**Development Review Board (DRB)  
Review Comments  
Utility Development Section  
Reviewer: Jon Ertsgaard, P.E.  
Phone: 505.289.3028**

<b>DRB Project No:</b>  1008585	<b>Date:</b>  05/09/2018	<b>Item No:</b>  #3
<b>Zone Atlas Page:</b>  J-9	<b>Legal Description:</b> Tract(s) 3, AVALON SUBDIVISION  <b>Location:</b> on the NE corner of DAYTONA RD NW and 90th ST NW, south of I-40	
<b>Request For:</b> 18DRB-70113 EPC APPROVED SDP FOR BUILD PERMIT (18EPC-40004)

ENGINEER'S SEAL 	UTILITY TRAILER SALES PROJECT LOCATION	DRAWN BY LA
	CONCEPTUAL UTILITY PLAN	DATE 05/23/2018
TIERRA WEST, LLC 5571 MIDWAY PARK PLACE NE ALBUQUERQUE, NM 87109 (505) 858-3100 www.tierrawestllc.com		2017041_MUE 2
RONALD R. BOHANNAN P.E. #7888		SHEET # C3
		JOB # 2017041

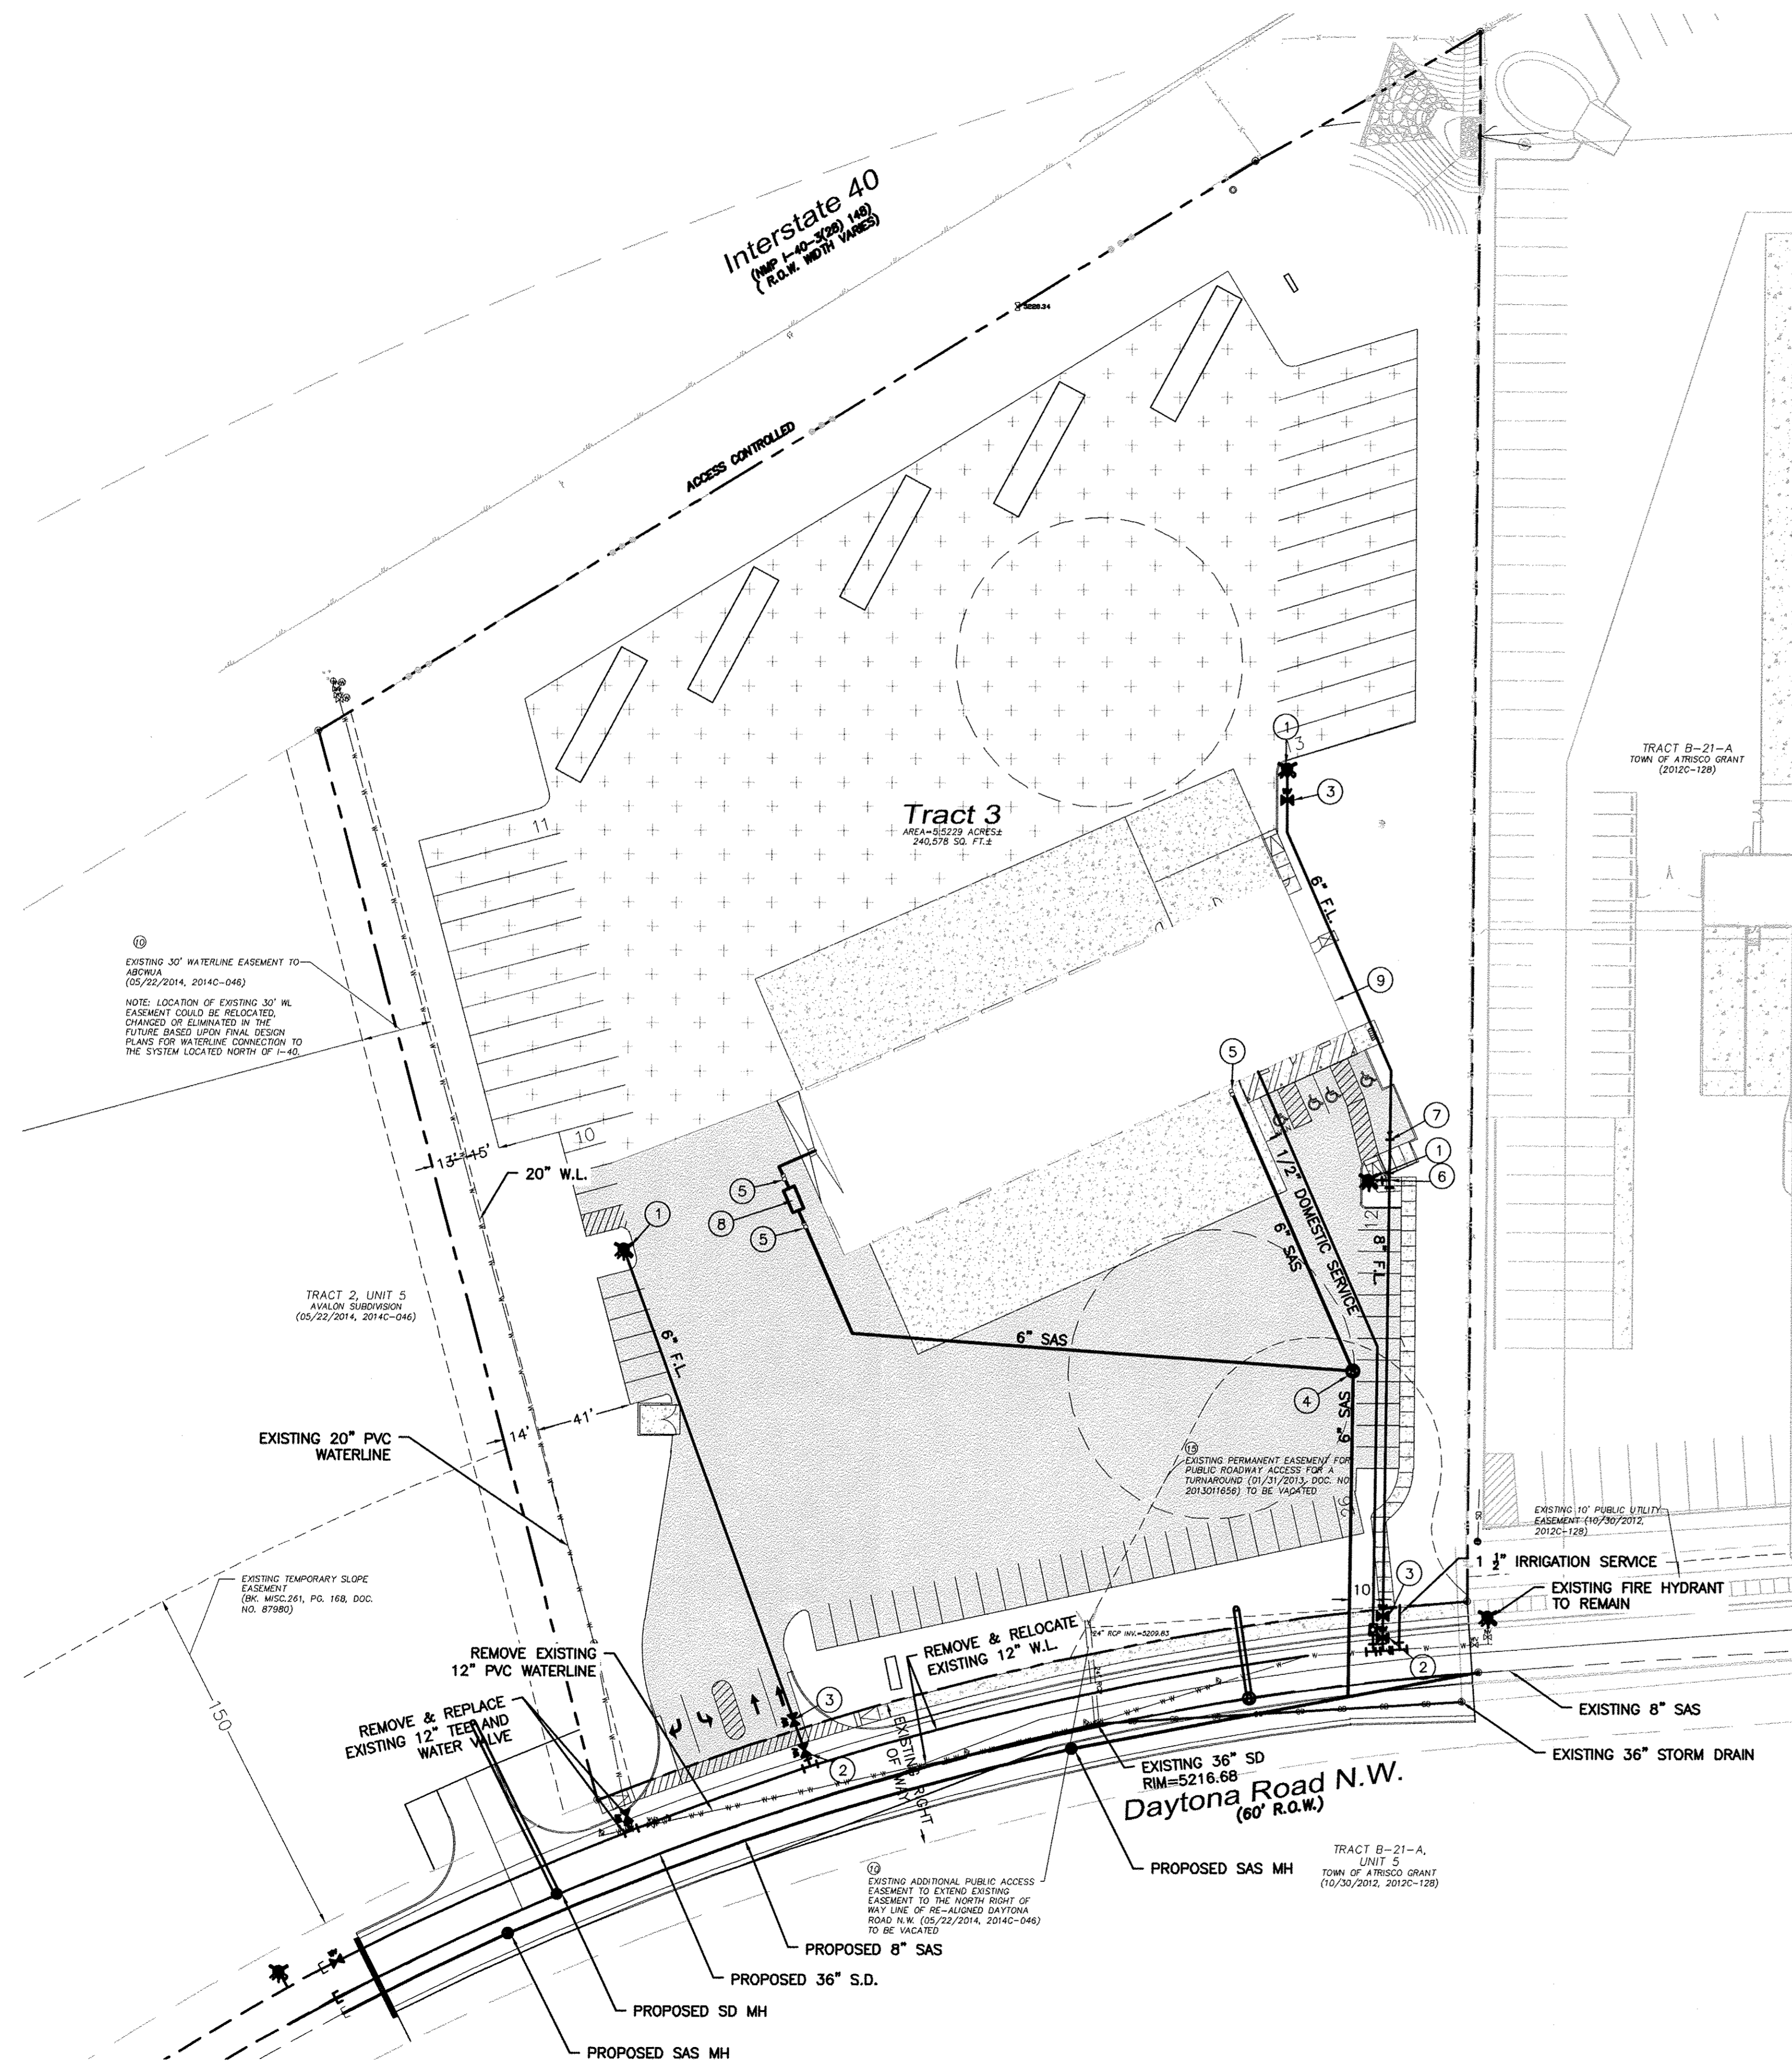
1. A Water and Sanitary Sewer Availability Statement (#180314) has been drafted and is currently pending signature.
2. Approval of the SDP for Building permit requires that the Utility Plan, Fire 1 Plan, and the availability statement agree.
3. An infrastructure list is required to include any new required public water and/or sanitary sewer infrastructure.
4. The water prorata assessment on the subject property has been paid.
